**Orchard End, Back Lane, Sibford Ferris, OX15
5QN**

21/00917/F

Proposal: Alterations to existing garage to replace existing pair of doors with single automated door to afford improved vehicular access; erection of carport and change to external surfacing to provide level, safe and protected access for wheelchair user from house to car/garage and vice versa

REVISION	DATE
PROJECT: Orchard End, Back Lane Sibford Ferris	
CLIENT: Mr C Matthews	
DRAWING: Carport & Garage Alterations Site Plan Proposed	
DRAWING NUMBER: 5041/22	
SCALE 1:100 @ A1L	DATE March 2021
DRAWN ND	CHECKED RC

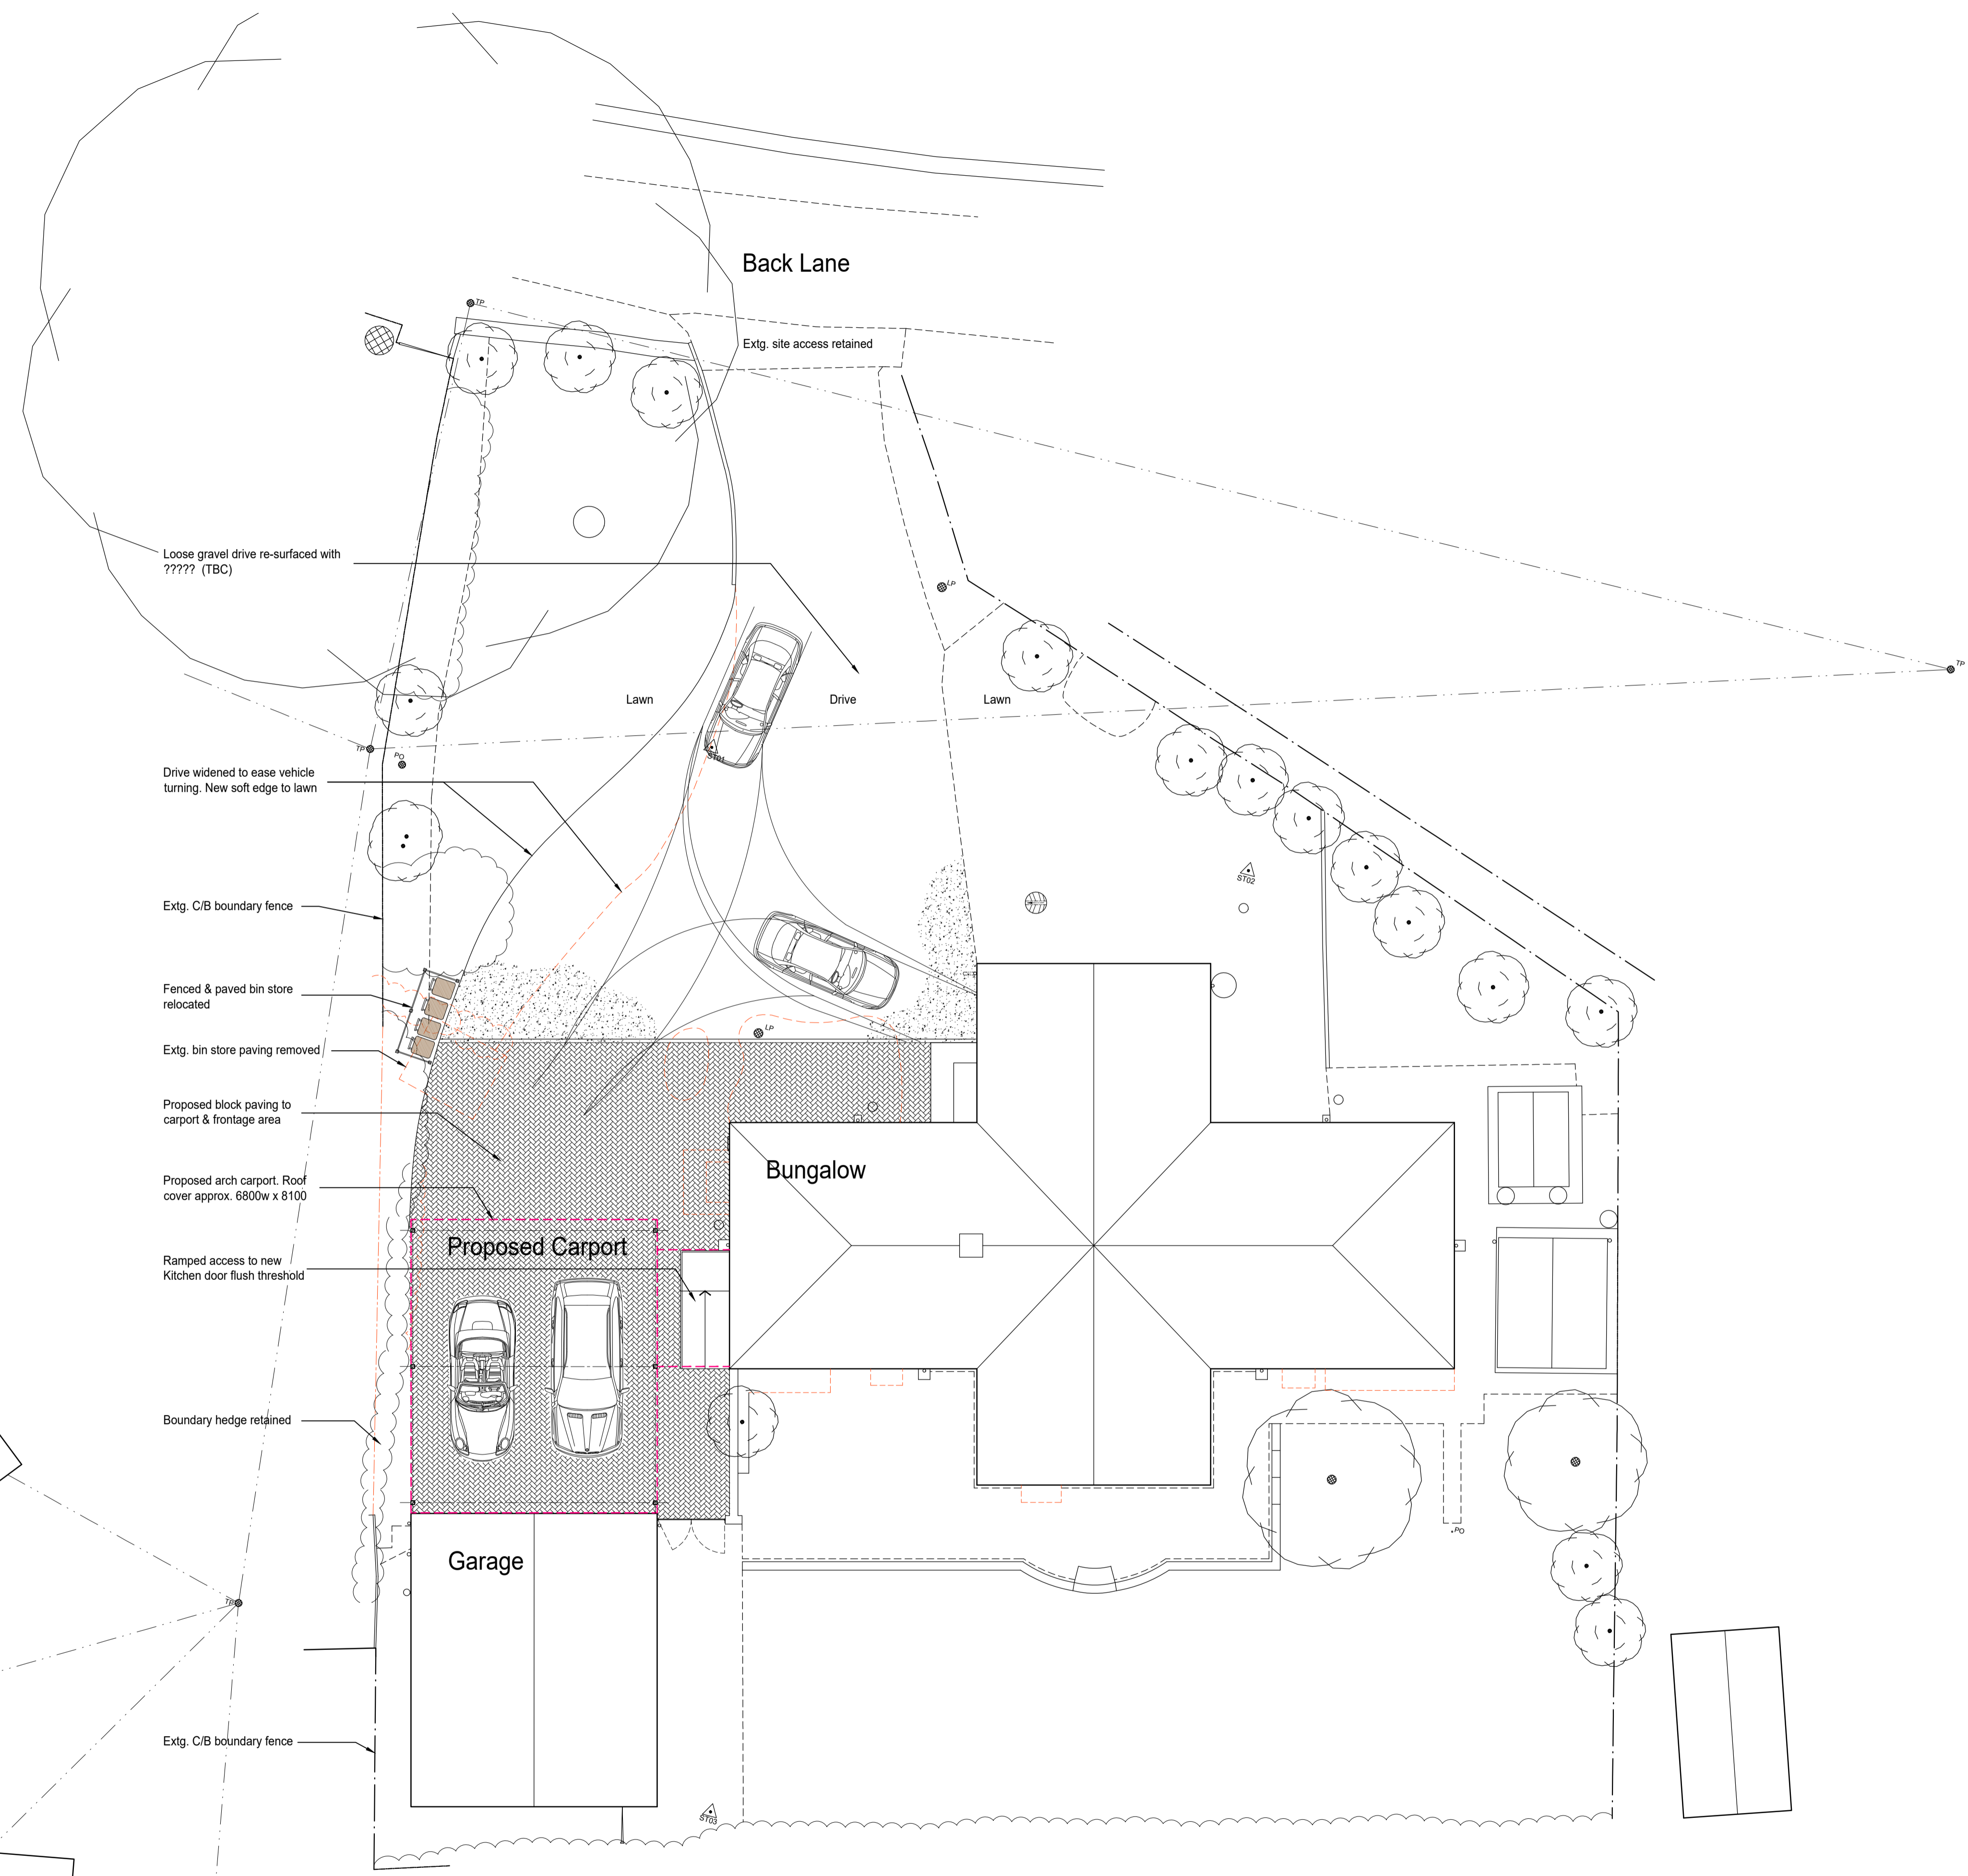
- The proposed block paving to replace some of the existing gravel at the driveway is considered to be an appropriate alteration to the front of the site as it would be a high quality material and match the brick character of the property.

3. Prior to the first use/occupation of the development hereby approved, the parking and manoeuvring areas shall be provided in accordance with the plan approved (Drawing No. 5041/22) and shall be constructed from porous materials or provision shall be made to direct run-off water from the hard surface to a permeable or porous area or surface within the curtilage of the site. Thereafter, the parking and manoeuvring areas shall be retained in accordance with this condition and shall be unobstructed except for the parking and manoeuvring of vehicles at all times.

REVISION	DATE
PROJECT: Orchard End, Back Lane Sibford Ferris	
CLIENT: Mr C Matthews	
DRAWING: Carport & Garage Alterations Elevations	
DRAWING NUMBER: 5041/21	
SCALE 1:50 @ A1L	DATE March 2021
DRAWN ND	CHECKED RC

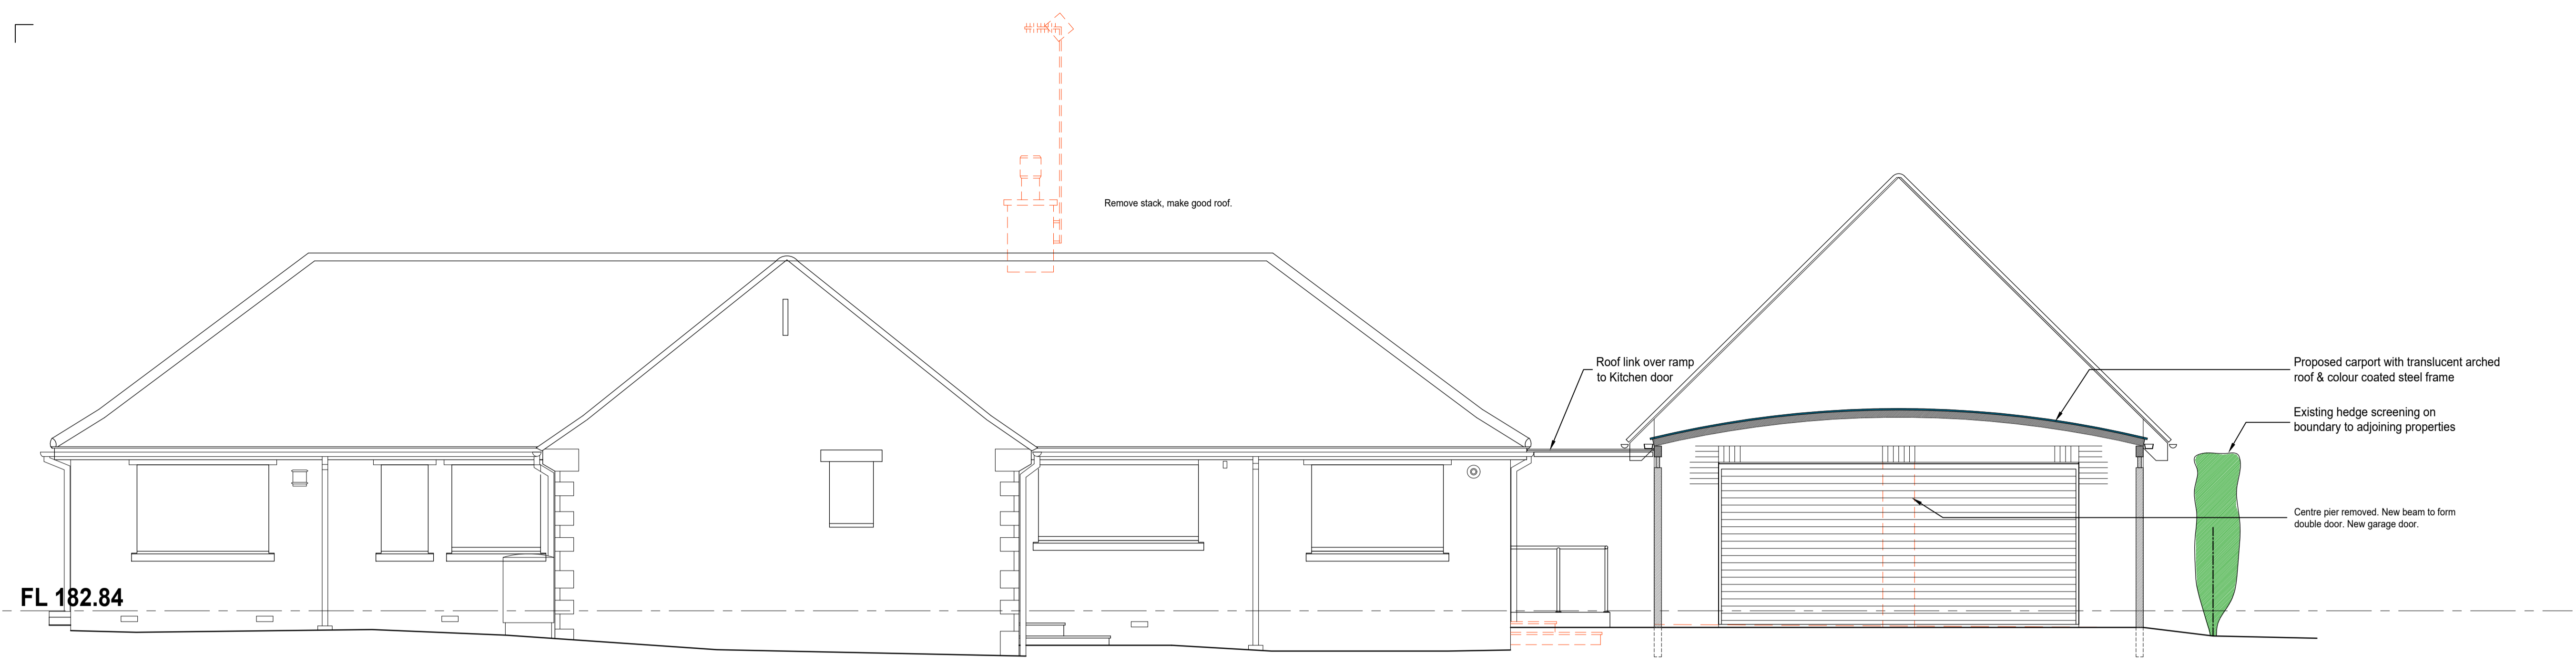
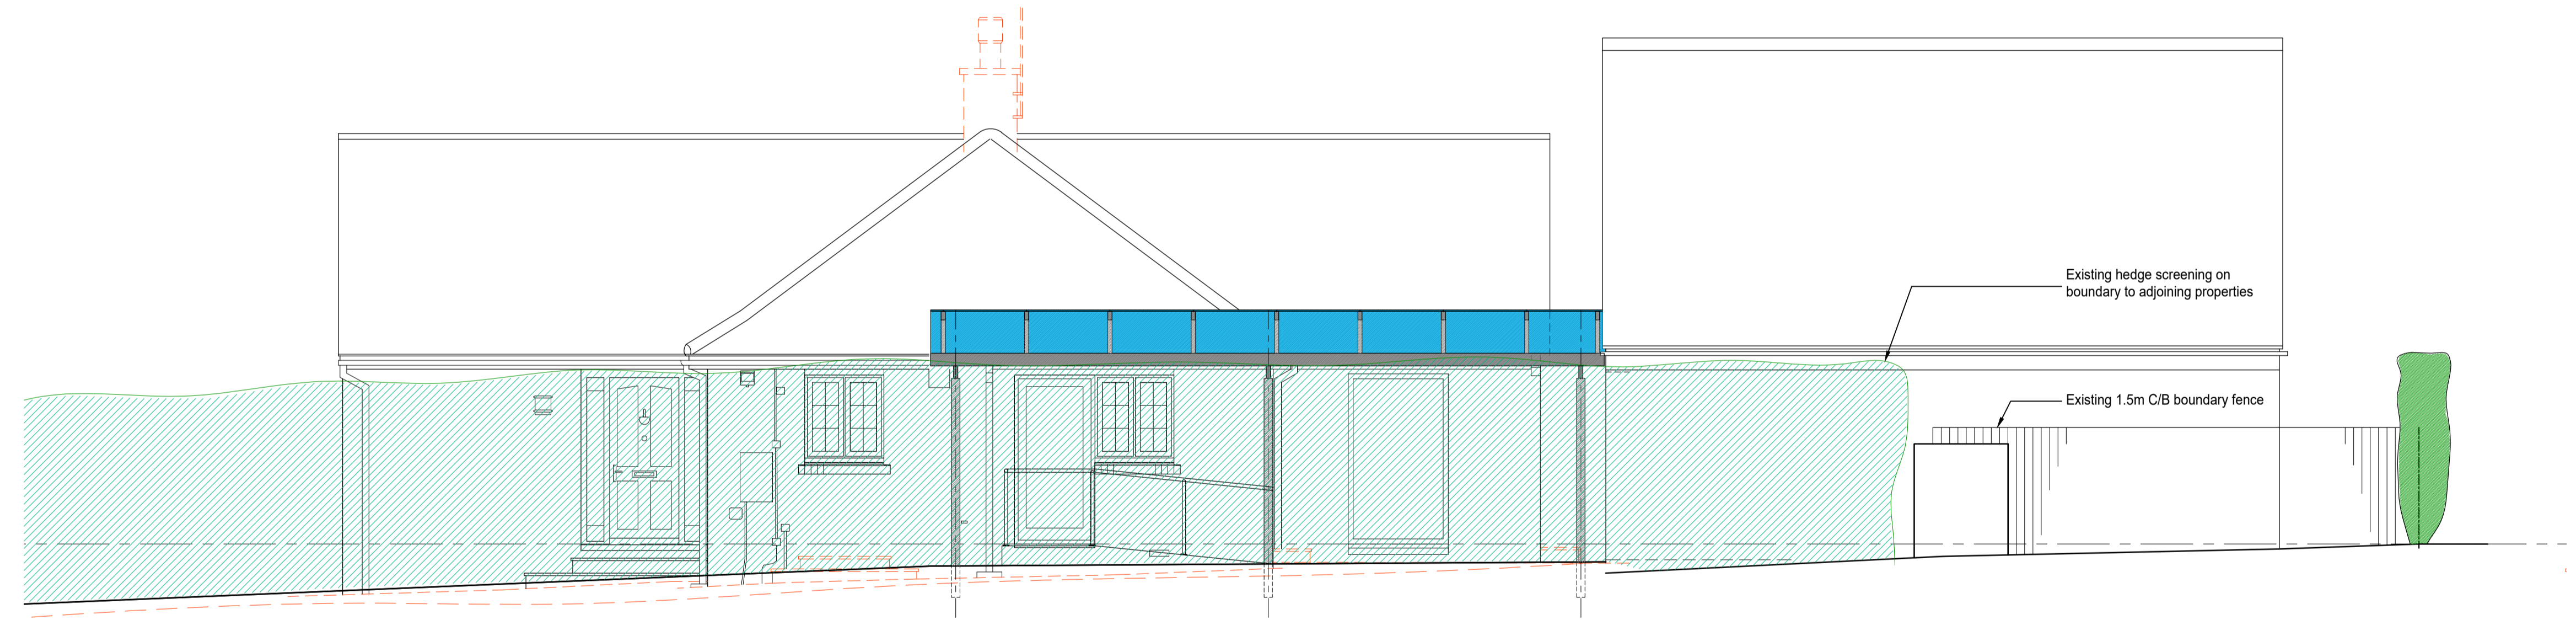
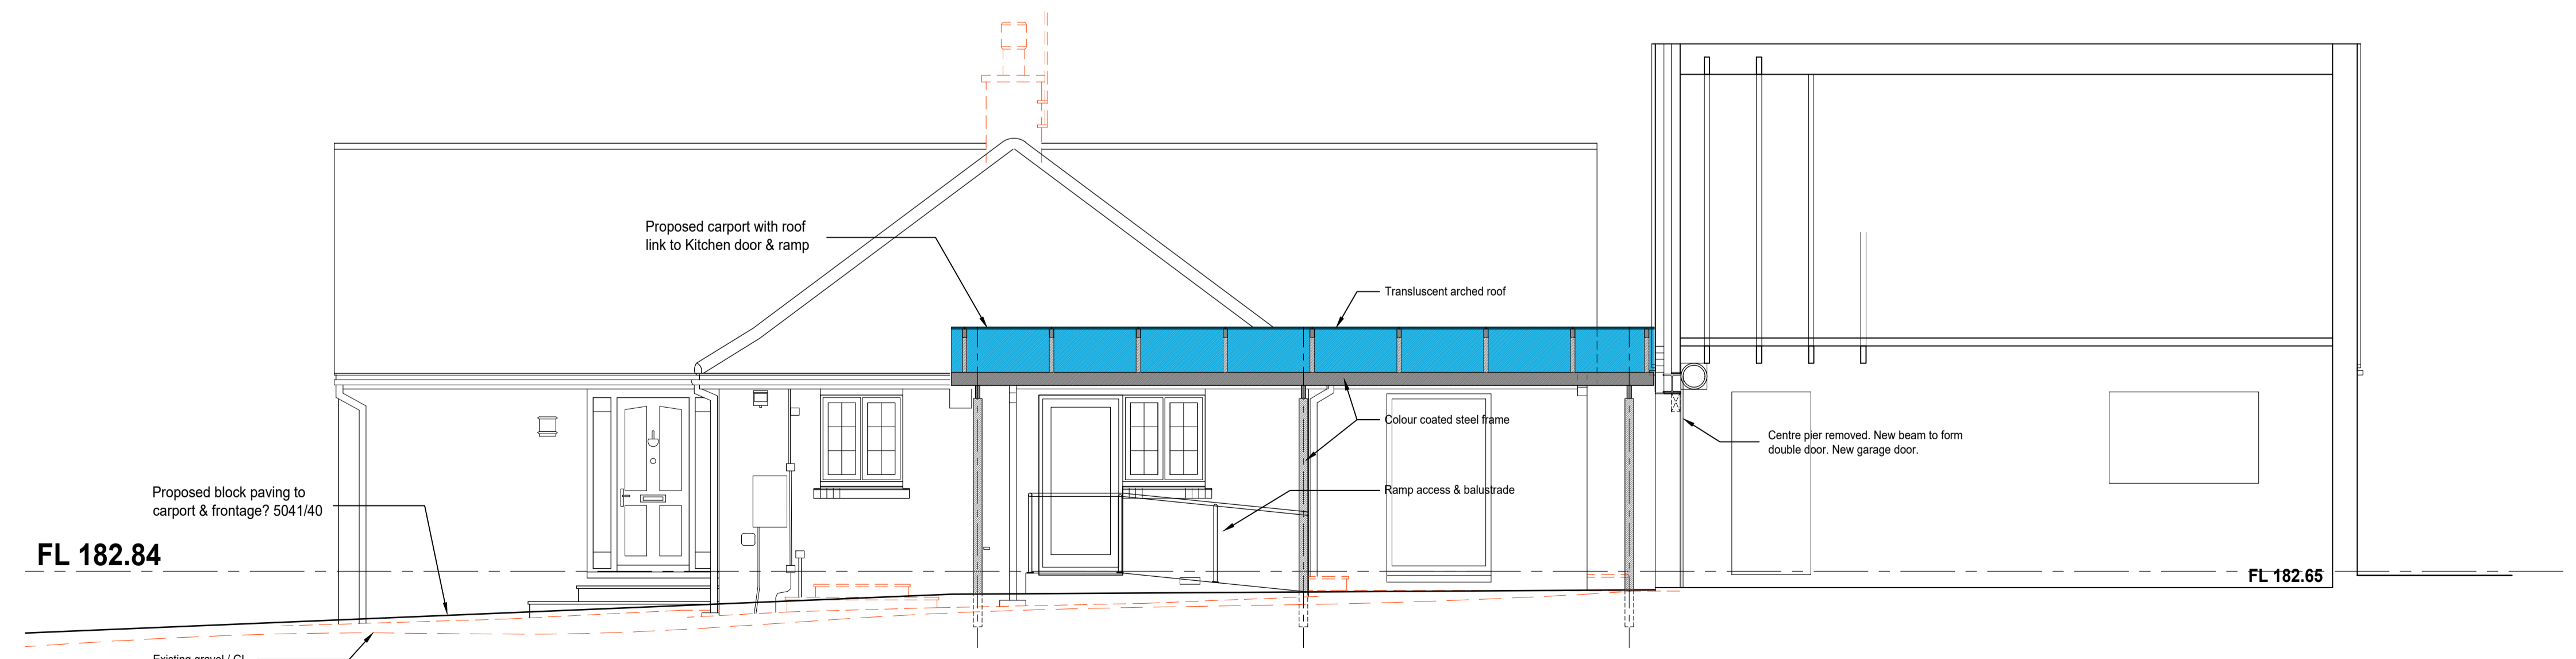
- Whilst there is not a wide palette of materials on the site or locality the steel framed car port with translucent arched roof would not be overly dominant when viewed from the streetscene and is significantly set back from the public domain and so its impact on the character of the area would be minimal.

- The proposed automated door is of a typical design for a domestic garage and would improve disabled access and as such there are no objections to this alteration.

- The proposed car port would be in close proximity to the rear boundary of 15 Cotswold Close. The structure would be relatively low in height, smaller than the existing garage and would be set away from the rear elevation of the dwelling. As such it is considered that the development would not impact on the neighbours in terms of loss of light, loss of outlook or overbearing.
- There would not be any habitable space added to the property as a result of the development and as such there would not be any impact on privacy in the locality,
- The replacement garage door and proposed block paving would have no impact on the amenity within the locality.
